TECHNICAL NOTE 1

DATE:	27 April 2023	CONFIDENTIALITY:	Public
SUBJECT:	A66 NTP Noise and Vibration Queries - Deadline 7		
PROJECT:	A66 NTP	AUTHOR:	Various
CHECKED:	Sarah Whydle	APPROVED:	Hywel Roberts

A66 NORTHERN TRANS PENNINE NOISE AND VIBRATION ASSESSMENT

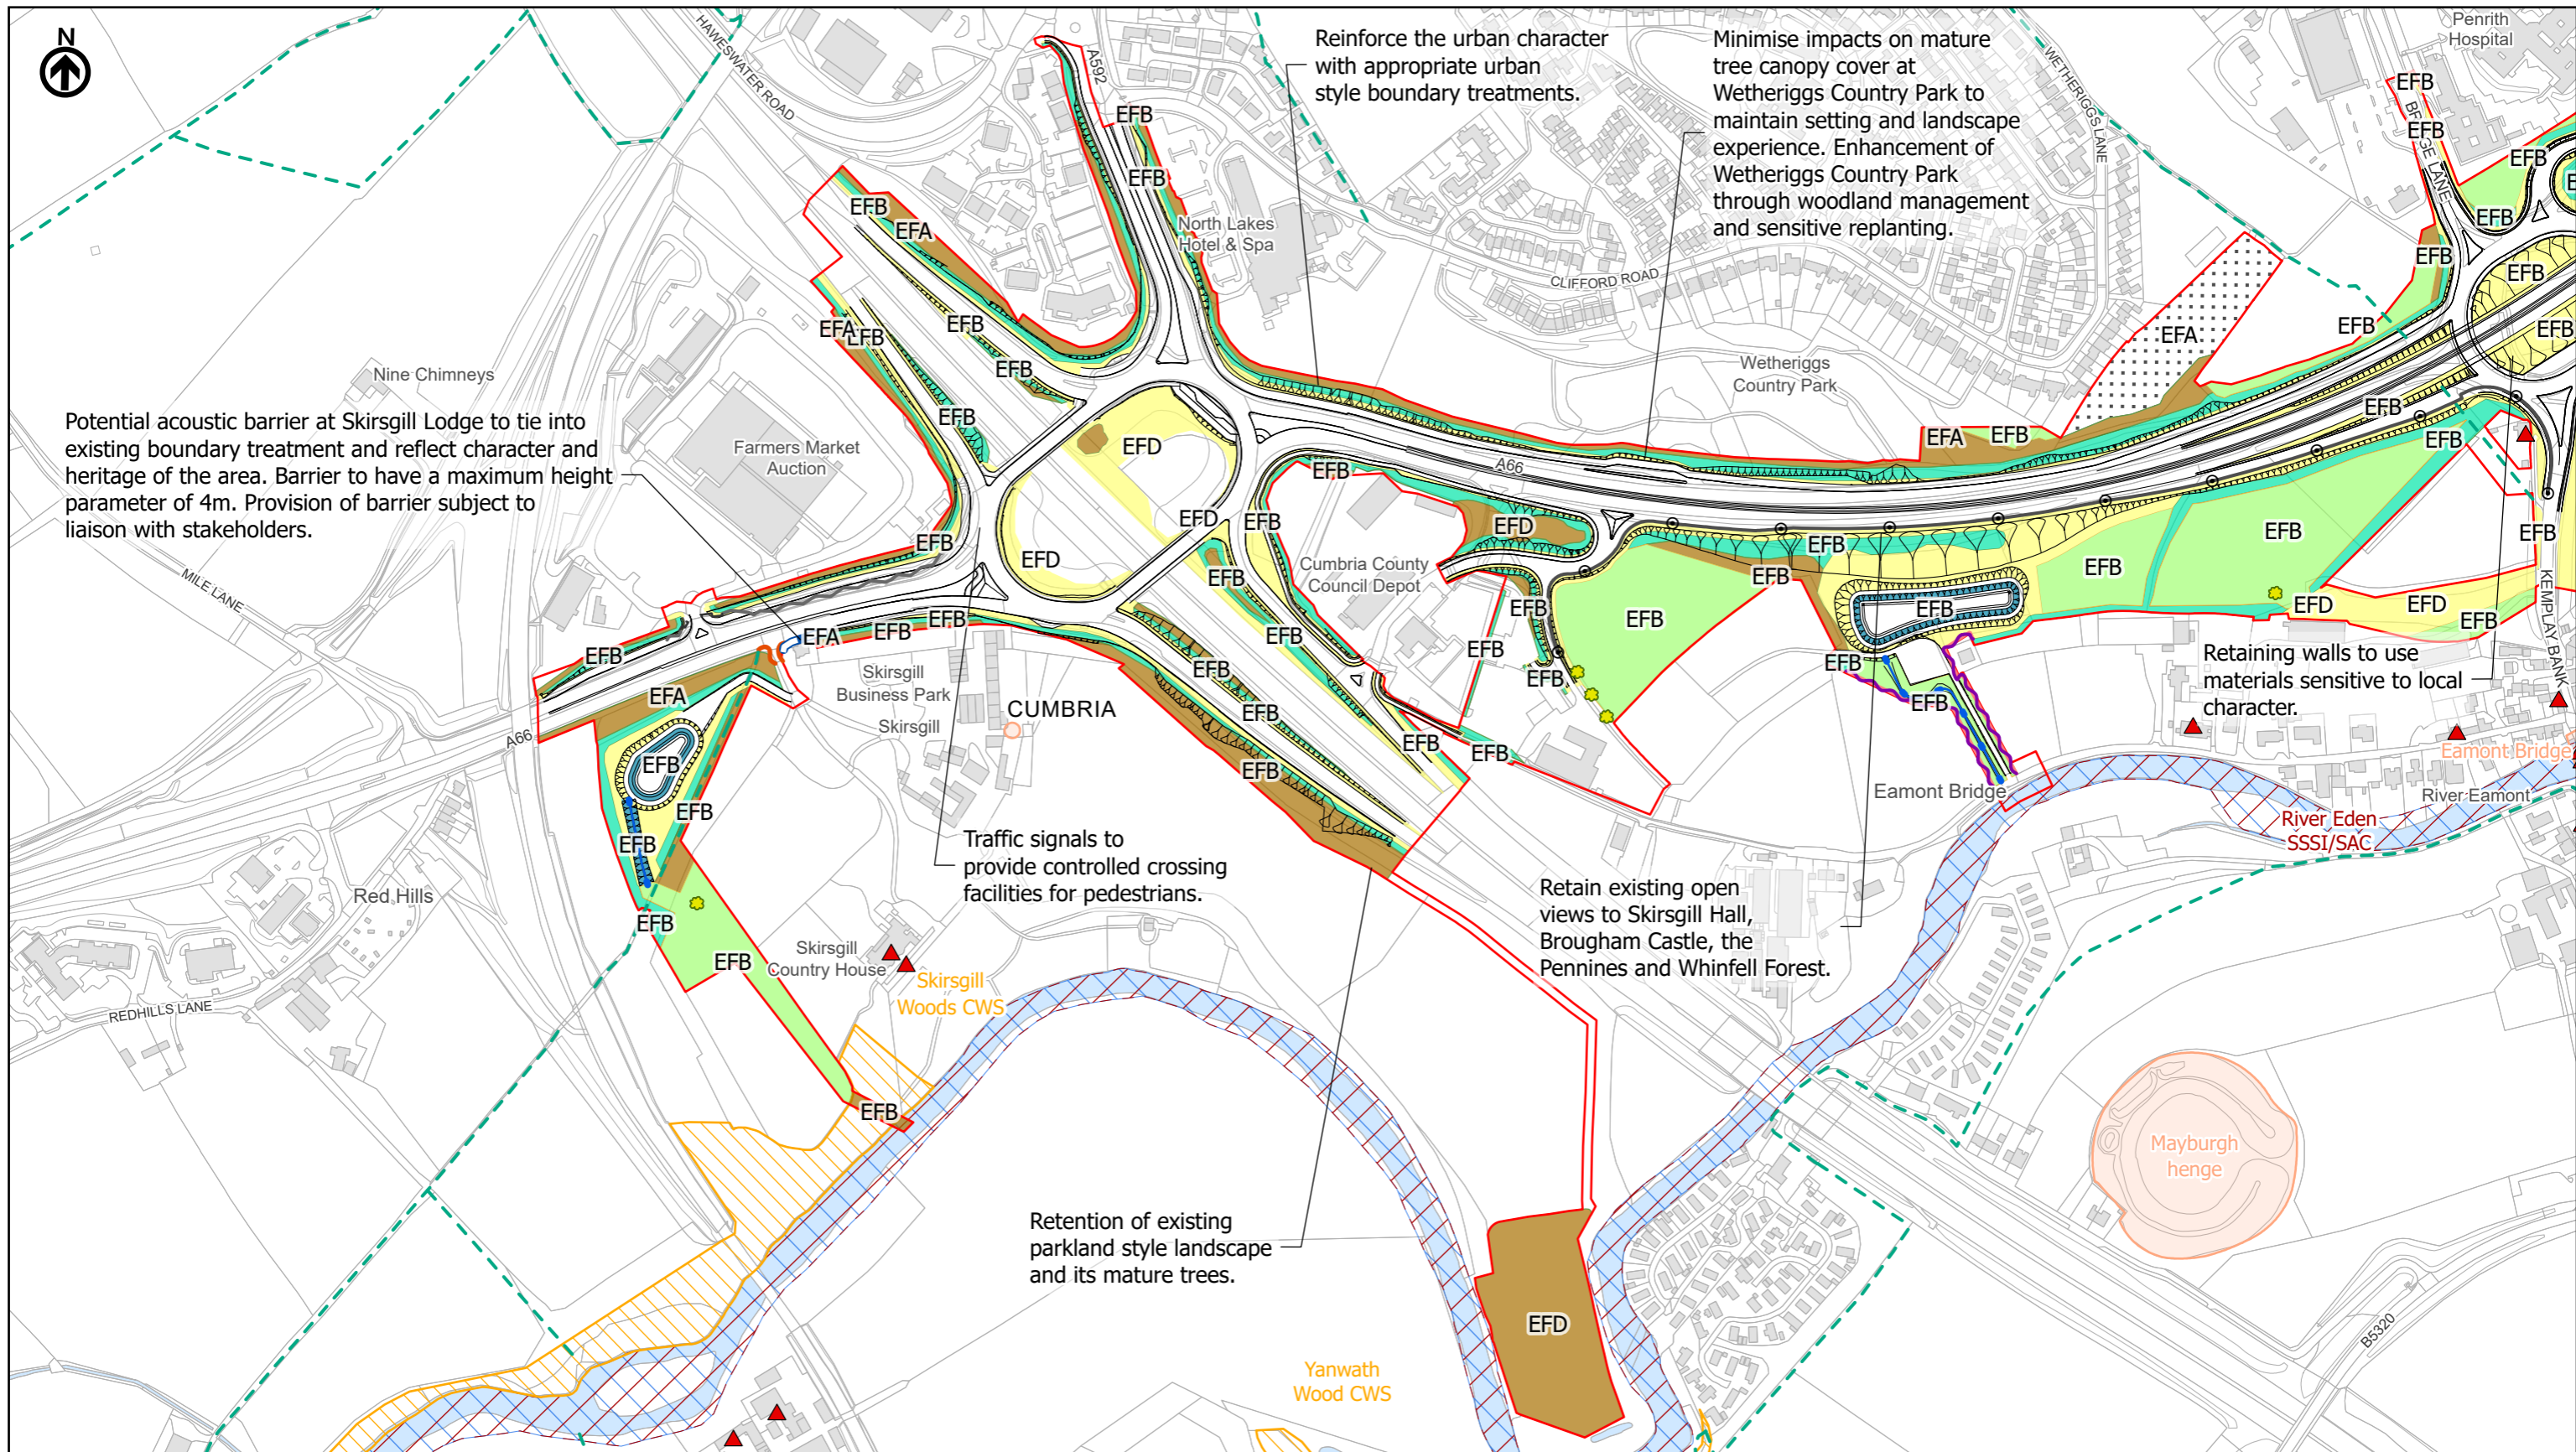
Deadline 6 Comment from NH	Council comment
<p><i>The comment provided references D-NV-03 but given it concerns Skirsgill Lodge, it is assumed this should read D-NV-02. Appropriate noise mitigation, in the form of a barrier, has been identified and set out in the Environmental Statement. However given the nature of Skirsgill Lodge and its location immediately adjacent to the road, there are implications of installing a barrier at this location, not least landscape and visual impact from and towards the property. National Highways therefore believes it is appropriate to allow for ongoing engagement with both the property holder and the local authority to agree the most appropriate mitigation to be implemented. The Environmental Statement is based on a worst-case assumption that the resident would prefer not to have the barrier, and therefore a significant effect from noise is reported, in Chapter 12 Noise and Vibration (APP-055), at this location absent a barrier. This information is in front of the examination and will be available to the Secretary of State to allow them to make an informed decision given the nature and proximity of the property to the road at this location.</i></p>	<p>The Council acknowledges the Applicant’s comments and is agreeable to deferring the design of any mitigation as the Applicant suggests but would like explicit inclusion in REAC commitment D-NV-02 in the first bullet to allow the consideration of a stone barrier that is in keeping with the architectural merit of Skirsgill Lodge. The first bullet would therefore read as follows with additional text in red: “The PC must engage with the residents of Skirsgill Lodge to establish whether they would support the implementation of the Barrier (which could be made of stone in consistent style to the existing boundary wall).”</p>
